Reference No:	2025/62/92081/W
Site Address:	46, Woodhouse Grove, Fartown, Huddersfield, HD2 1AS
Description:	Erection of two storey rear extension
Recommending Officer:	Joshua Merriman

HOUSEHOLDER DELEGATED REPORT

Application Number	2025/92081
Location	46, Woodhouse Grove, Fartown, Huddersfield, HD2 1AS.
Proposal	Erection of two storey rear extension and partial single storey side.
Publicity end date	12/09/2025
Number of representations received	None.
Kirklees Local Plan Allocation/Designation	The application site is located within a bat alert layer, and within an area at high risk of ground movement due to previous coal mining activity.
Extension to Time (EoT)	Yes EoT Date: 04/11/2025
Recommendation	Conditional Full Permission

CLIENT	Mr Saghir		
ADDRESS	46 Woodhouse Grove HD2 1AS		
PROJECT	Two Storey Rear Extension		
DRAWING	Existing and Proposed Layout and Elevations		
DRAWN	UH	DATE	Feb 25
		SCALE	1.100@A1
DWG No.	2518/02		
STATUS	PLANNING

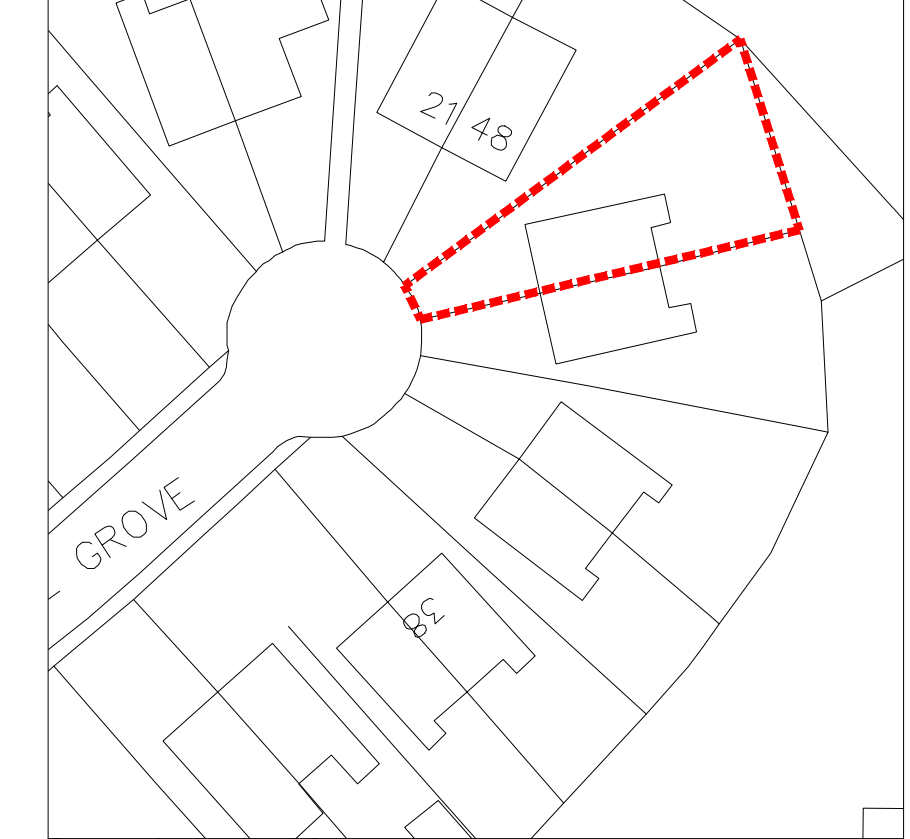
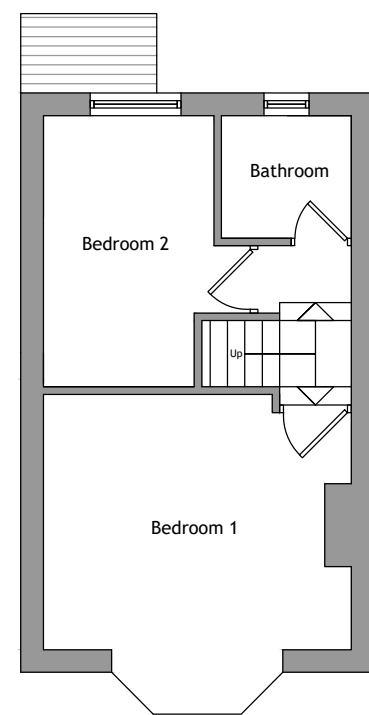
YES / NO	SUMMARY
Negotiations/Amendments during course of application	Yes	It was requested that the two-storey rear extension was set away from the shared boundary as to reduce impacts on the residential amenity of the adjoining dwelling, with a ‘wraparound’ style of the extension suggested to maintain adequate space. Amended plans were then submitted, setting in the extension to adhere to the 45-degree rule from the neighbouring rear windows and thus having an acceptable impact upon residential amenity. Further publicity was not deemed necessary due to the amendments

house or by 4 metres for detached properties	exceeding the 3m allocated for semi-detached dwellings.	
not exceed a height at the eaves of 3 metres where the extension is within 1.5 metres of the property boundary		The extension has an eaves height of 4.89m within 1.5m of the property boundary, exceeding the 3m eaves height guideline, however, as the extension does not cut the 45 degree angle to neighbouring rear windows, it is considered that there will be no significant impact on the adjoined dwelling and the proposal can be acceptable in this regard.
be separated from the property boundary, such as a wall, fence or hedge, by at least 1.5 metre		As aforementioned, the extension is within 1.5m of the Southern property boundary, however, it is not considered to have any significant impact upon neighbouring properties and thus is acceptable in this case.
not adversely affect habitable room windows where they adjoin a neighbour's boundary	The proposal will not cut the 45-degree rule to the neighbouring rear window closest to the adjoined boundary, therefore, there is considered to be no significant impact upon habitable room windows.

Pursuant to article 35 (2) of the Town and Country Planning (Development Management Procedure) Order 2015 and guidance in the National Planning Policy Framework, the Local Authority have, where possible, made a pre-application advice service available, complied with the Kirklees Development Management Charter 2024 and otherwise actively engaged with the applicant in dealing with the application. The case officer sought amendments to the location of the rear extension to ensure there were no significant impact upon the residential amenity of neighbouring occupiers. Following the communication of this to the applicant, amended plans were submitted detailing the movement of the extension away from the shared boundary, overcoming concerns.
